Recommendation Report for Planning Permission for Works or Extension to a Dwelling

REF NO: EP/109/25/HH

LOCATION: 94 North Lane
East Preston
BN16 1HE

PROPOSAL: Proposed loft conversion, first floor rear extension and alterations to fenestration.

Drawing Name
Ground Floor, First Floor and Roof Plans -
Proposed

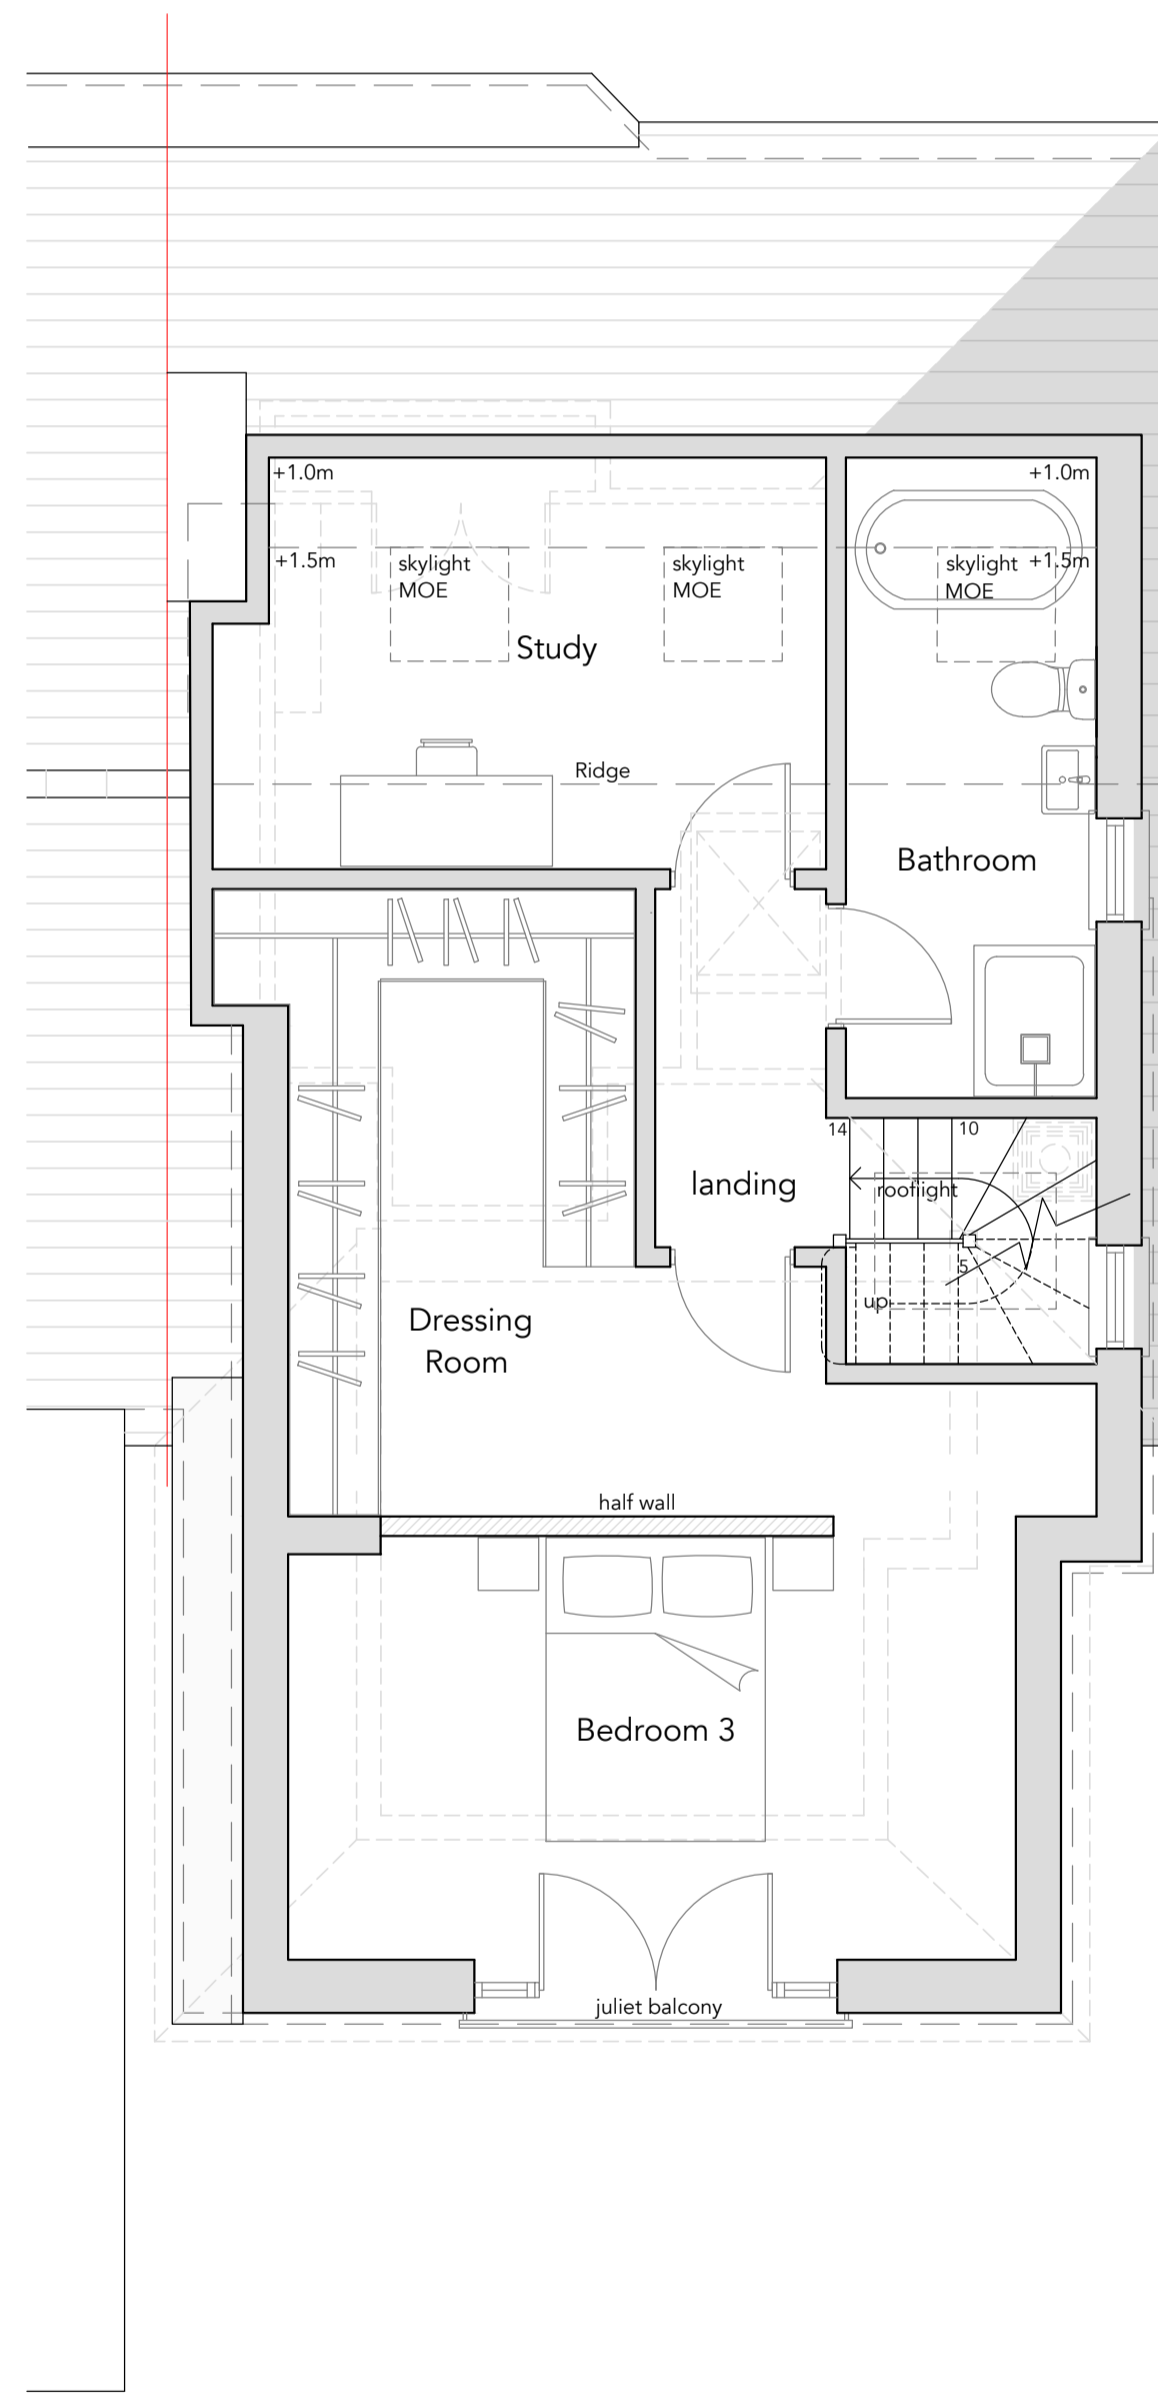
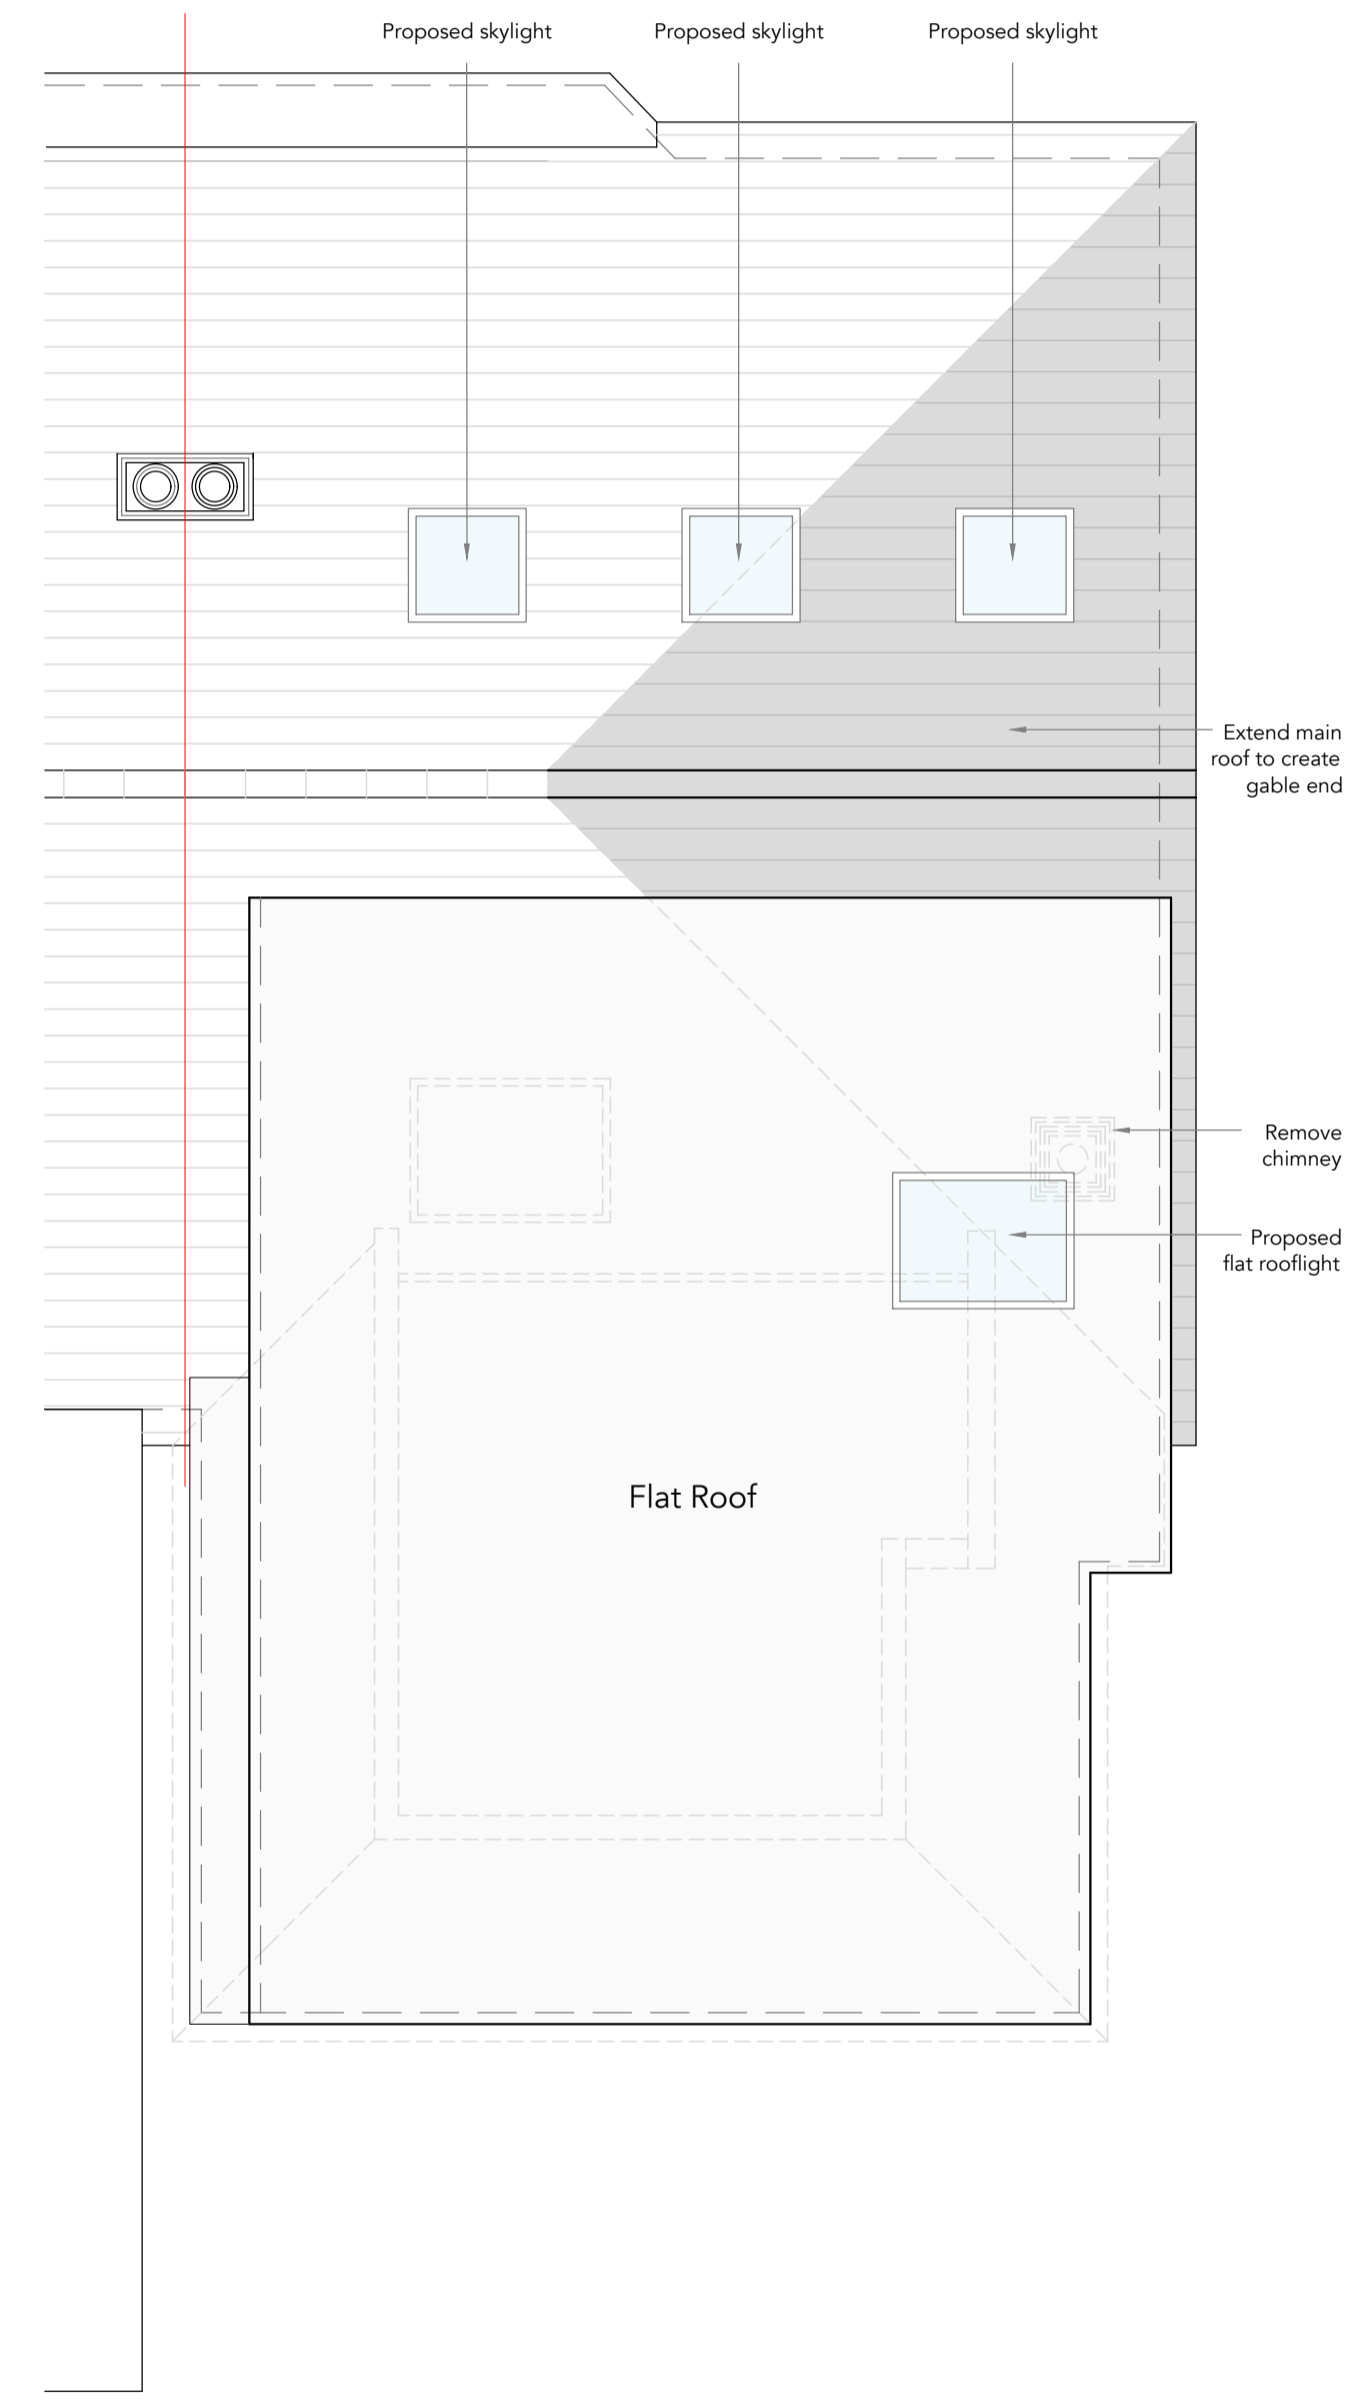
Existing fenestration at ground floor level would be maintained and three rooflights are proposed to the front (south) roof slope. The rooflights would be proportionate in scale and number in accordance with policy 1 of the East Preston Neighbourhood Plan (EPNP). Furthermore, there are examples of front rooflights in the street scene and therefore would not result in any harm in this regard.

The proposed hip to gable roof extension would increase the bulk and massing of the dwelling closer to the neighbouring property to the west. The first floor extension would be set in approximately 0.5m from the eastern side boundary and would not comply with the minimum guidance of 2m for a first-floor extension outlined in policy M of the ADG. Given that the neighbouring dwelling to the east has an existing single-storey flat roof extension that projects beyond the rear of the host dwelling and that this neighbour has no existing fenestration within the rear at first floor level within the rear roof slope, the proposed loft conversion and first floor extension would not result in overbearing, overshadowing, or overlooking impacts to the neighbour to the east.

The loft conversion and first floor extension would maintain the existing separation distance of approximately 0.65m to the western side boundary. It is noted that this would not comply with the minimum guidance of 2m for a first floor extension outlined in policy M of the ADG. However, given the existing high boundary treatments and the fact that the proposal is above an existing building rather than a new footprint or encroachment, any additional impact in terms of overshadowing or overbearing would not be unduly harmful. On balance, level of harm would be minimal and would not be sufficient to justify a refusal of the proposal.

Elevations -
Proposed

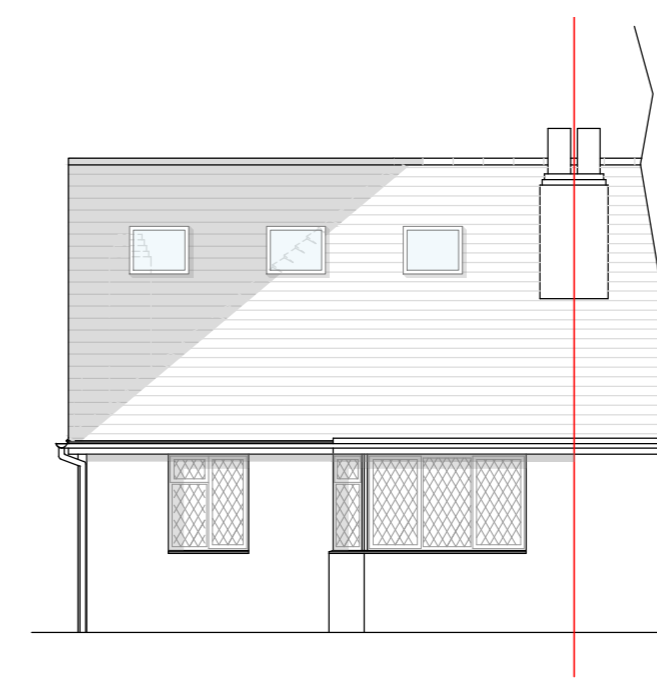
East Preston Parish Council - No objection, however, the following is to be noted.
The committee asked ADC to be particularly aware of how the proposed alterations could unbalance this pair of bungalows. The committee was also concerned about whether the proposed two-storey extension at the rear of the property would lead to undue overlooking of the neighbours. The same concern was raised about the proposed Juliet balcony on the same elevation.

On the side (west) elevation, the proposal would maintain the approximate depth of 12.7m. The proposed loft conversion and first floor extension would extend over the existing single storey rear projection, increasing the height by 1.9m to 5.7m and increasing the maximum eaves height by 3m to 5.4m. The proposed flat roof would be finished in grey EPDM and contain a single flat rooflight (western flank) and would be finished in white uPVC. The rooflight would be in accordance with Part M of the Arun Design Guide (ADG) as it would maintain the privacy of the neighbouring properties. The development would alter the bulk of the host dwelling; and it is noted that the proposal would not be a subservient addition to the host dwelling, however the main roof ridge height of the dwelling would be retained, and the development would not project beyond the original footprint of the property which helps to minimise any visual harm upon the locality and complies with the ADG.

The proposal would be finished with horizontal weatherboard in grey to first-floor dormer cheeks and gable end, and the existing chimney would be removed.

Proposed fenestration on the side (west) elevation at ground-level would remove an existing window, whilst at first floor level there would be two new obscurely glazed and non-openable windows finished in white uPVC.

Proposed fenestration on the rear (north) elevation at ground level would be maintained, whilst at first floor level the proposed fenestration would replace the existing rooflight (northern roof plane) with a Juliet balcony. The proposal would be finished in white uPVC.

The proposed fenestration at first floor level on the western flank elevation would serve a bathroom and landing and would have an outlook of the side (west) neighbouring dwelling. These windows would be fitted with obscure-glazing and would be non-openable below 1.7m above the finished flood level. As such, the proposed windows would not result in any overlooking. Notwithstanding this, a condition has been attached to this planning permission to secure this in perpetuity, thereby ensuring there would be no overlooking or loss of privacy to the neighbouring (west) dwelling.

The proposed fenestration within the rear (north) elevation would include a Juliet balcony and would have an outlook of the rear amenity space serving the host dwelling. A comment has been received in relation to the perceived overlooking from the proposed Juliet balcony at first floor level. However, while the rear fenestration may offer limited views towards neighbouring gardens, these views would be oblique, restricted, and would not result in material harm. Furthermore, it is noted that a rear dormer with similar views could be constructed under permitted development. Therefore, on balance, the proposed rear fenestration would not give rise to unacceptable overlooking impacts to neighbouring (east and west) dwellings.

- 3 The windows at first floor level within the western side elevation of the dwelling shall at all times be and remain glazed entirely with obscure glass to a level equivalent to Pilkington Level 3 or nearest equivalent standard and be non-openable below 1.7m above the finished floor level. This arrangement shall be retained permanently thereafter.
